PORTLAND MAINE

March 29, 2006

RE: 243-245 High St.

243-245 High Street, Portland, Maine
 March 28, 2006

243-245 HIGH STREET  
HANDRAIL MODIFICATIONS  
NOT TO SCALE -  
DIMENSIONS ARE  
APPROXIMATE

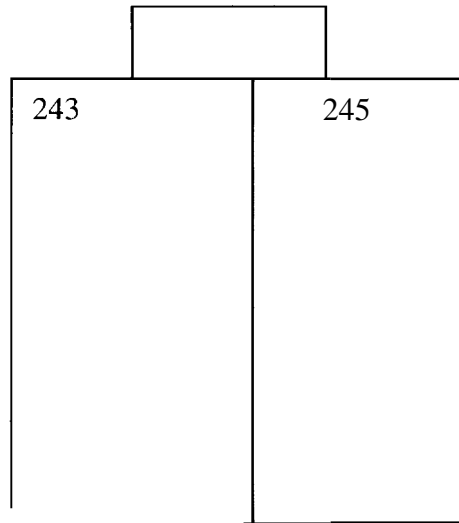
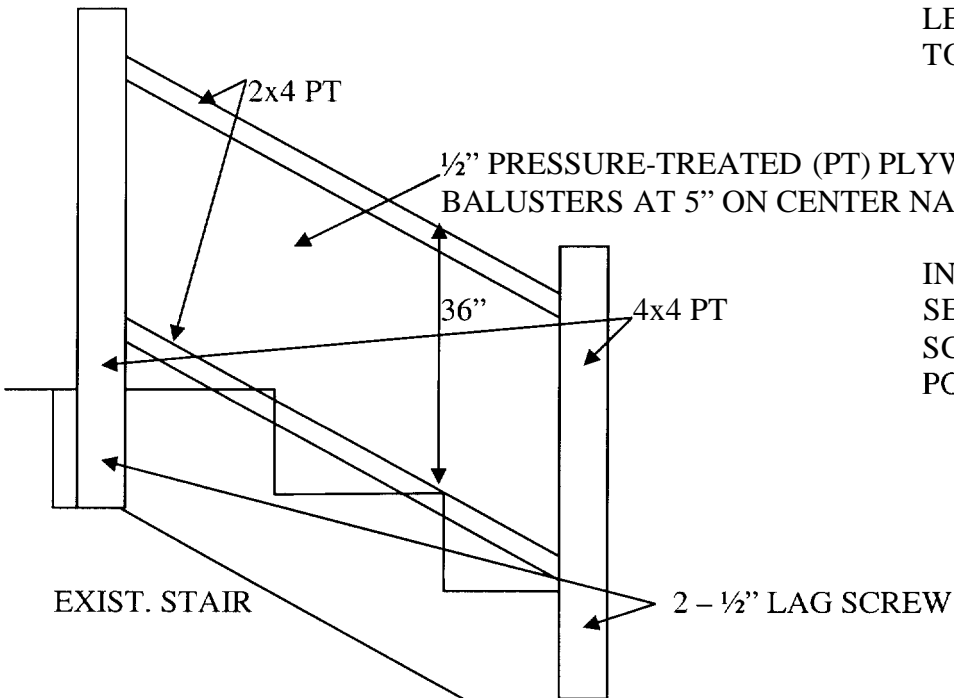
As we noted during the conference call, you have been making progress in bringing your High Street building into compliance with the City Codes. Your consultant distributed a document (attached) which detailed most of the outstanding items needed to be completed. In addition to those items, within the next week you will be providing the City 1) with a letter from your electrician, Tim Napolitano, that the basement wiring is in compliance with applicable electrical codes., 2) a certification from Dean and Allyn that the installed sprinkler system is up and running and 3) that the junk which has accumulated in the rear of the property (i.e. old appliances etc) will be removed in total within a week 4) you will be applying for a building permit to remove the two fire escapes on the building that no longer serve as a means of emergency egress, 5) your engineer will forward the written Fire Escape plan to Captain Greg Cass (they have verbally discussed the same and are in agreement on it) and 6) the plans submitted for the rear deck handrail and baluster system.
